Project Special Provisions
(Version 06.5)
Signals and Intelligent Transportation Systems

1. 2006 STANDARD SPECIFICATIONS FOR ROADS & STRUCTURES

The 2006 Standard Specifications are revised as follows:

SHEET 1 OF 3  
**1725D01**

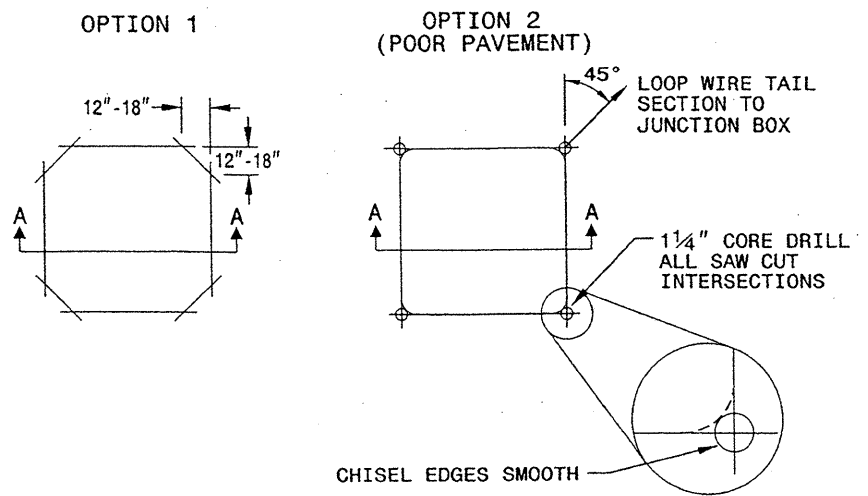
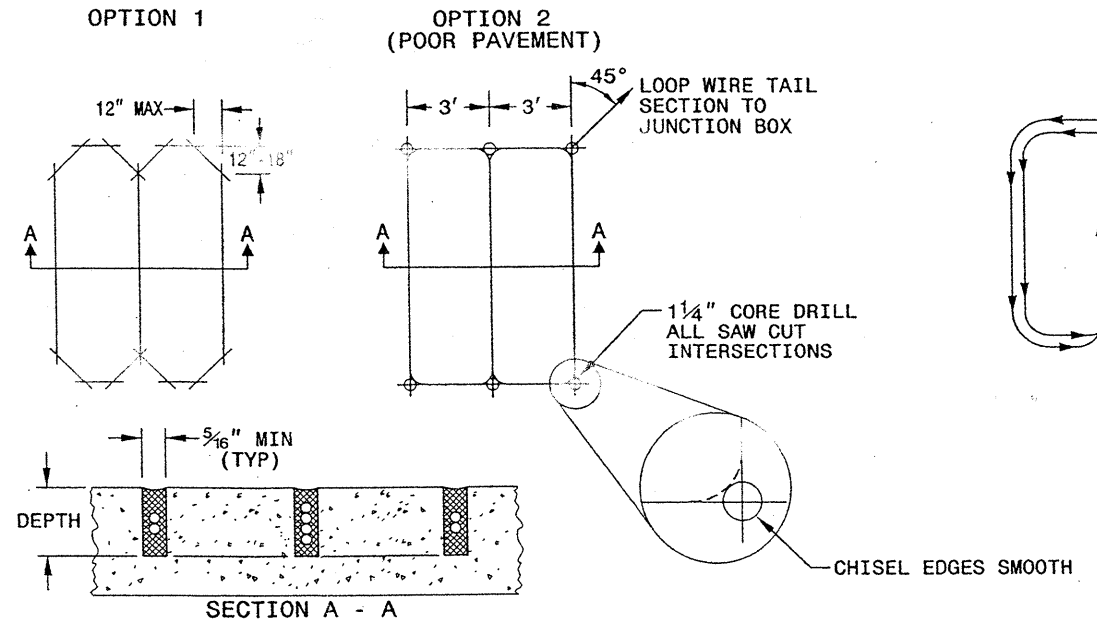
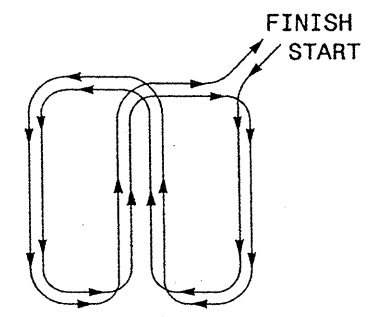
1.4. Inductive Detection Loops – Construction Methods (1725-3)

Page 17-20, Subarticle 1725-3, In the first paragraph on the page, revise the first sentence to:

“Twist loop conductor pairs a minimum of 5 turns per foot from where conductors leave saw slot to junction box.
